From: Thomas Callaway
Sent: 04 June 2015 10:34
To: Planning.Responses
Subject: RE: Planning Consultation on: A/50/15/PL
Attachments: Drainage - Supplementary Guidance Notes.pdf

Engineers comments in respect to surface water drainage:

APPLICATION NO: A/50/15/PL

Description of Works: Demolition of Spinney & Burberry House & erection of 2 Storey hotel annexe with associated car parking

DRAWING TITLE
DRAINAGE STRATEGY PLAN

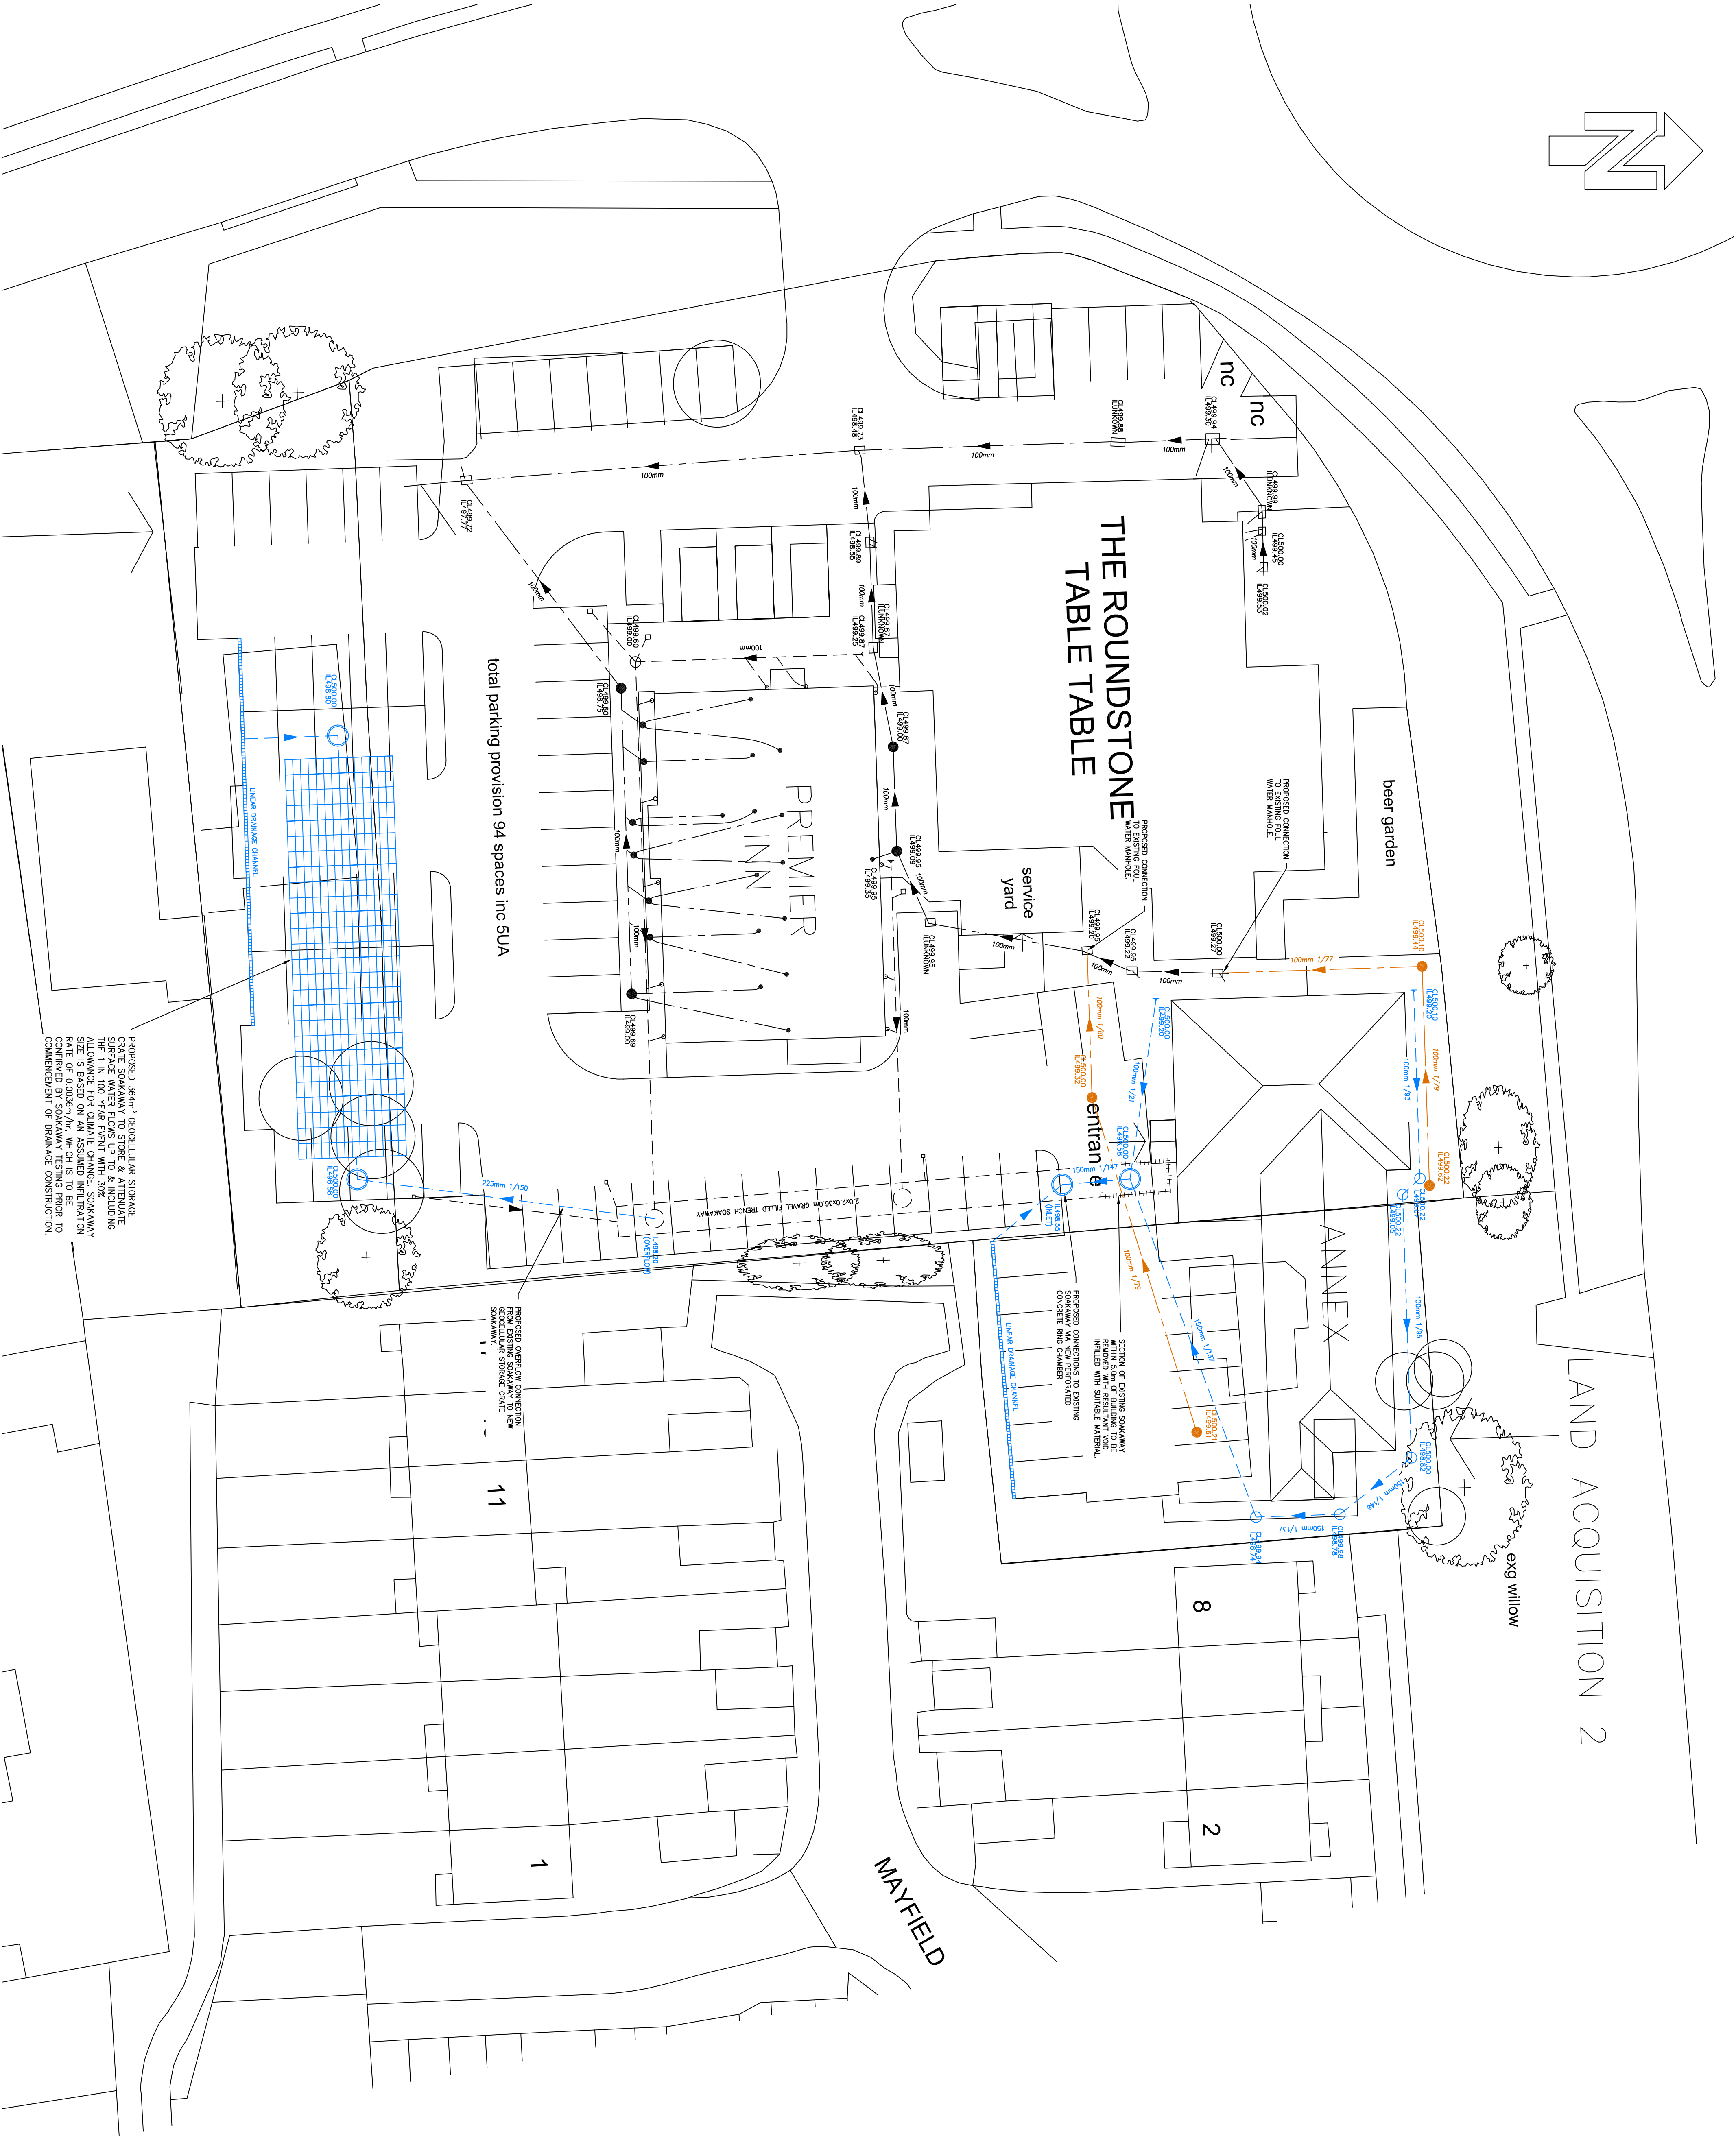
The applicant states that surface water will be discharged to soakaways. A new soakaway serving the proposed development is to be constructed beyond an existing soakaway. A trial pit should be dug in the existing soakaway to ensure it is functioning correctly, with silt traps added prior to each soakaway as necessary. Also the proposed soakaway location is the site of a building – the remnants of foundations etc and compaction of soil may lead to poor soakage rates so it may be beneficial to relocate the soakaway away from the site of the building to be demolished.

Infiltration rates for soakage structures are to be based on percolation tests undertaken in the winter period and at the location and depth of the proposed structures. The percolation tests must be carried out in accordance with BRE 365, CIRIA R156 or a similar approved method and cater for the 1 in 10 year storm between the invert of the entry pipe to the soakaway, and the base of the structure. It must also have provision to ensure that there is capacity in the system to contain below ground level the 1 in 100 year event plus 30% on stored volumes, as an allowance for climate change. Adequate freeboard must be provided between the base of the soakaway structure and the highest recorded annual groundwater level identified in that location.

Any SuDS or soakaway design must include adequate groundwater monitoring data to determine the highest winter groundwater table in support of the design. The applicant is advised to discuss the extent of groundwater monitoring with the Council's Engineers. Supplementary guidance notes are also enclosed for information.

Please apply standard conditions ENGD2A.
